From: Anita Gardner <Anita.Gardner@arun.gov.uk>
Sent: 02 November 2021 14:33
To: Planning.Responses <Planning.Responses@arun.gov.uk>
Subject: FW: Dappers Lane, Angmering -A/ 210/21/DOC

From: Anna Gillings [REDACTED]
Sent: 02 November 2021 14:28
To: Anita Gardner <Anita.Gardner@arun.gov.uk>
Cc: Shaun Letchford [REDACTED] Sam Rous <[REDACTED]> Emma Patchell
[REDACTED]
Subject: Dappers Lane, Angmering - 210/21/DOC

Subject: RE: Dappers Lane - Drainage

Scale NTS	Date Jul '21	Drawn JS	Checked SL
Drawing No A360-08			Revision C

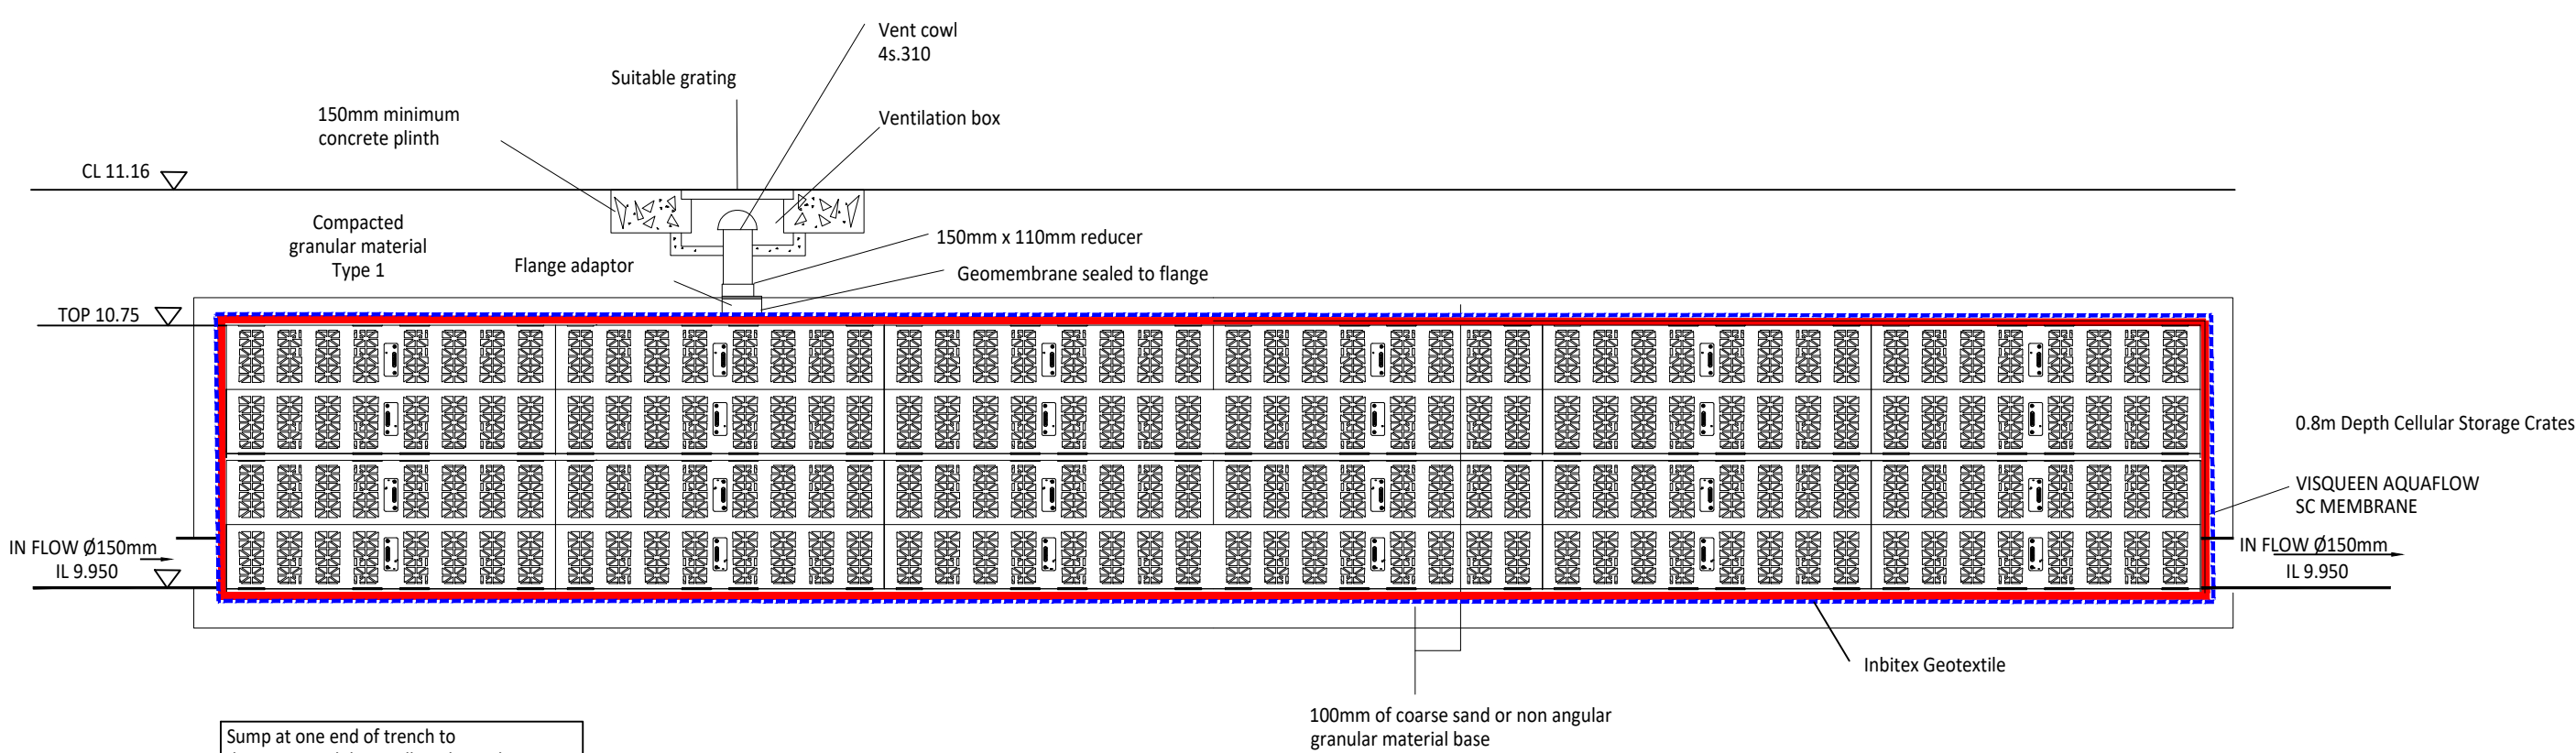
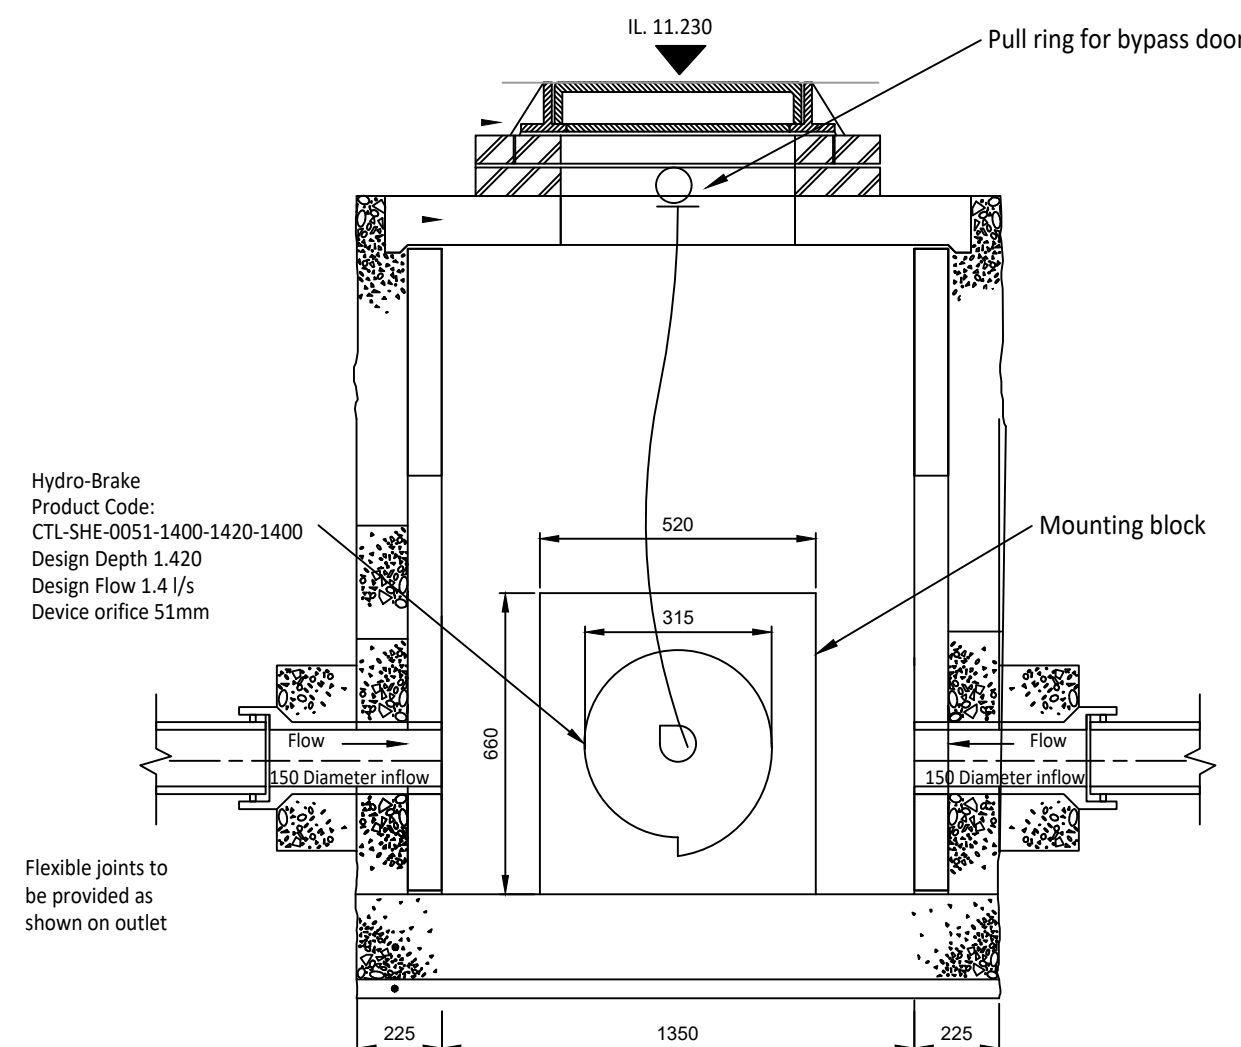
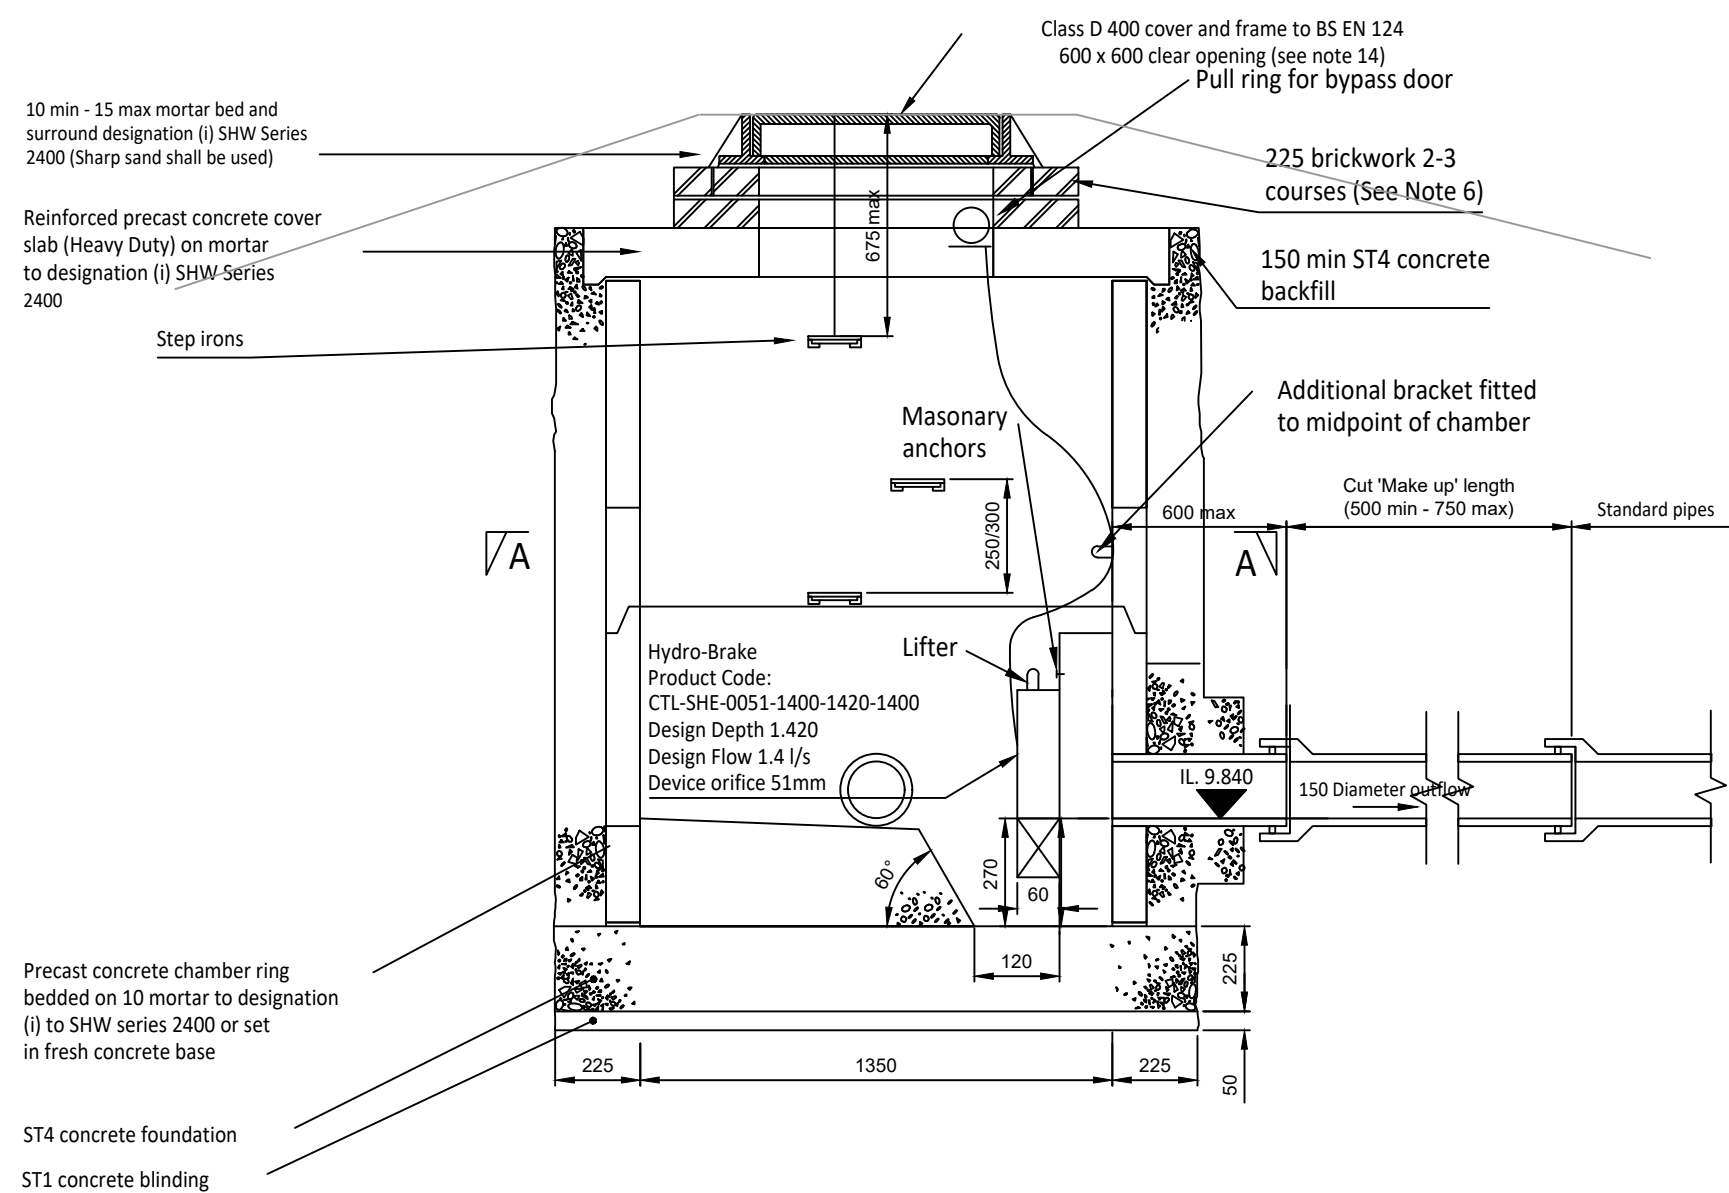
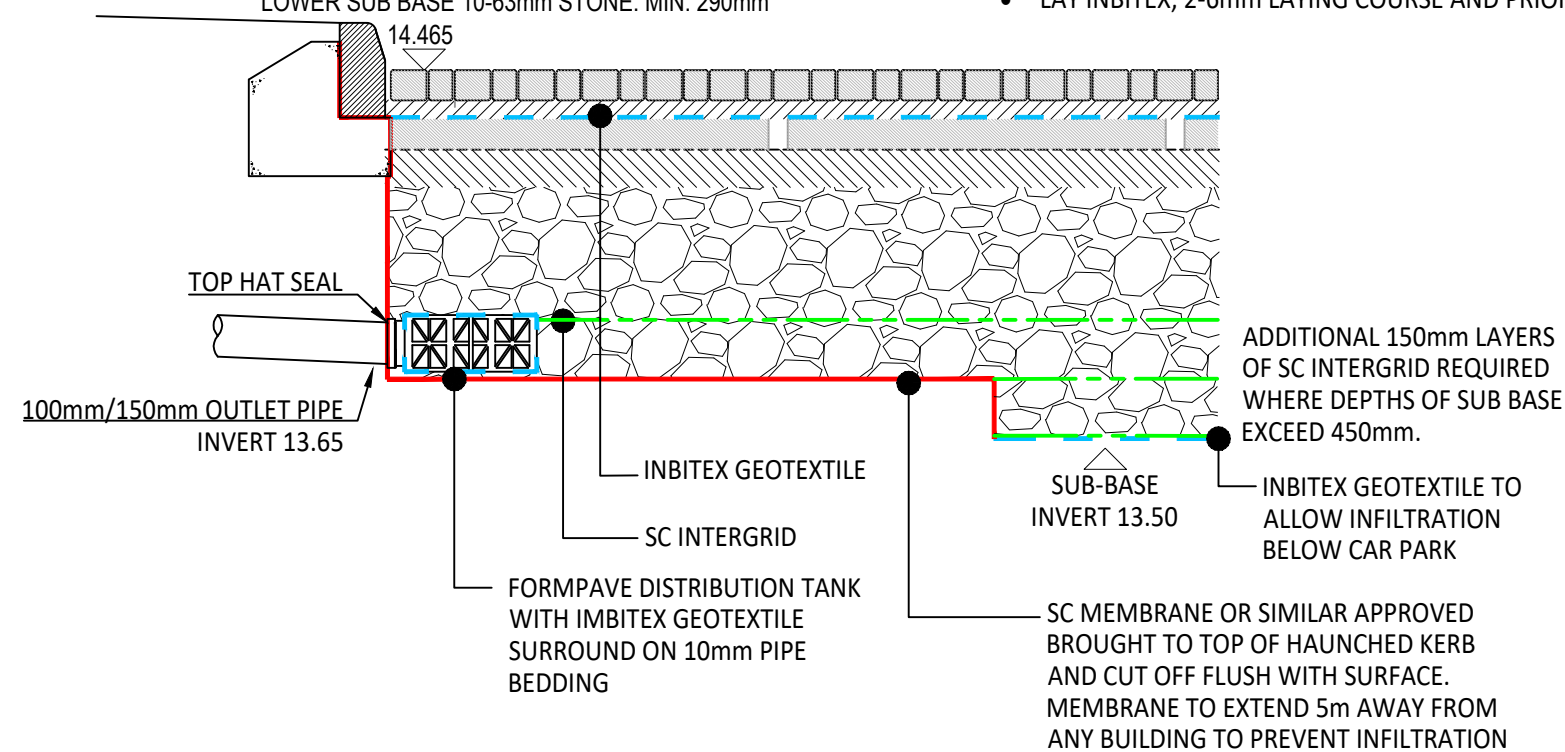
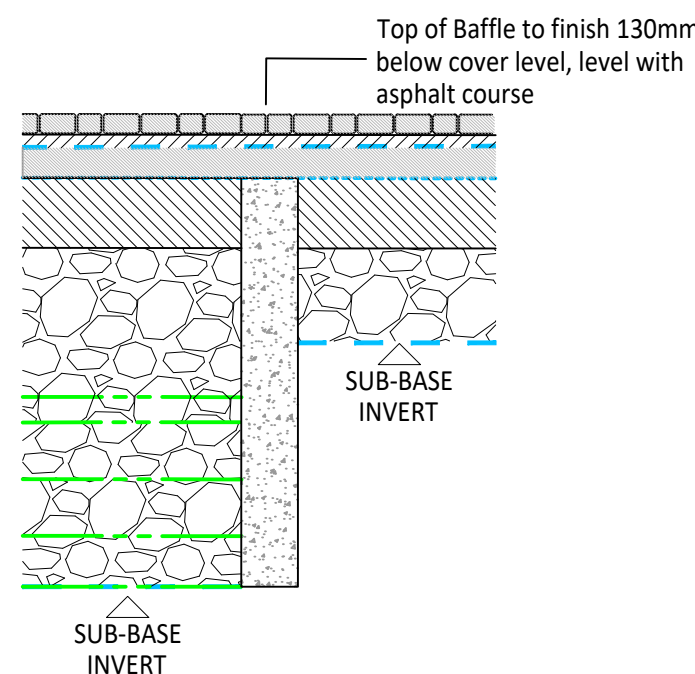
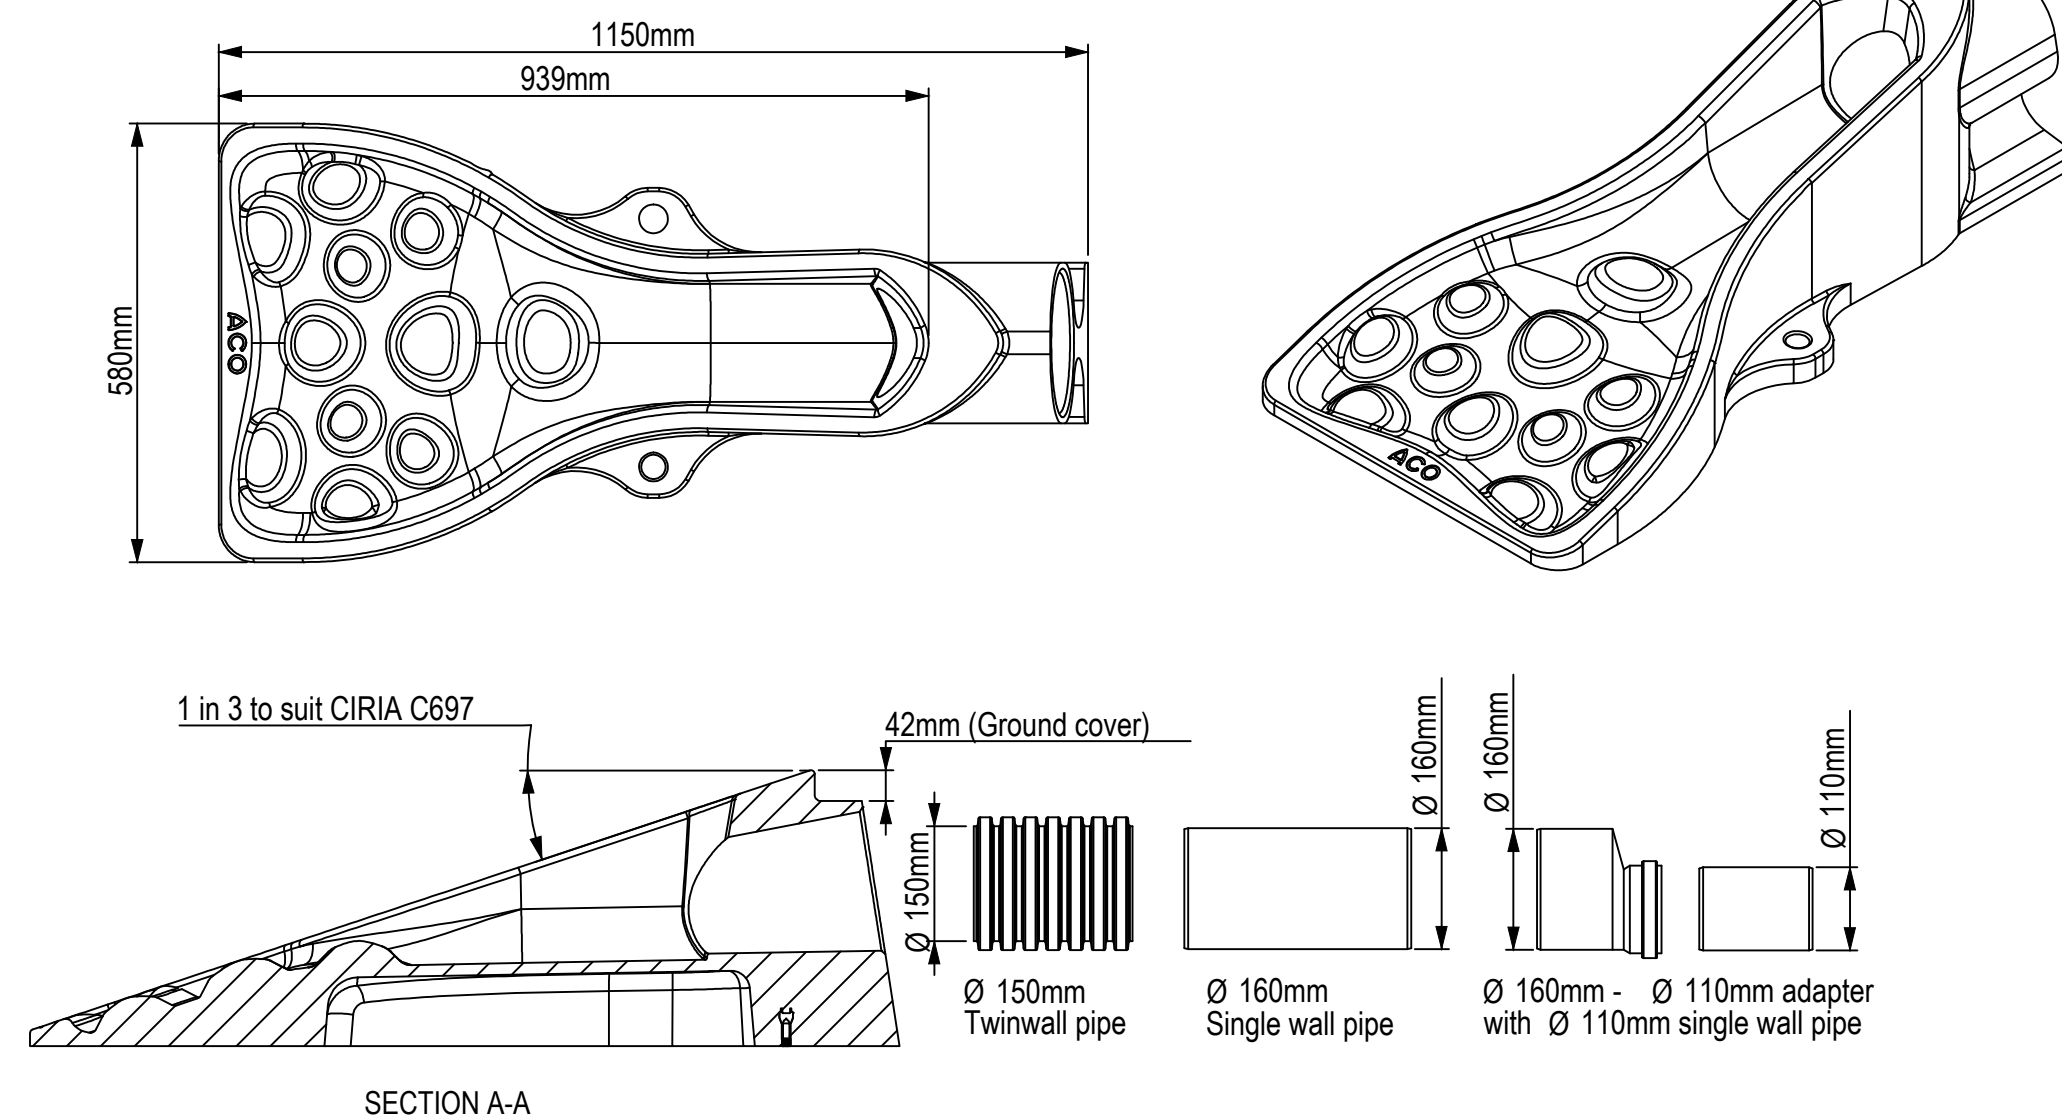
6. A construction detail drawing of the permeable paving is required. Including additional details showing diffuser block connections, and baffles. *Detail showing distribution tank does not appear to have been supplied. Awaited*

Many thanks for your comments. Please find attached the completed Ordinary Watercourse Land Drainage Consent which I believe is for Paul Cann (copied in). I have also updated A360-08 to address your comments regarding the distribution tank (point 6). With regards to your question on point 7 the SC membrane is noted to extend 5m away from any building on the blocked paved car park detail and also on the drainage strategy layout (A360-01). I have attached all drawings and calculations for your convenience, however please note that only drawing A360-08 has been updated.
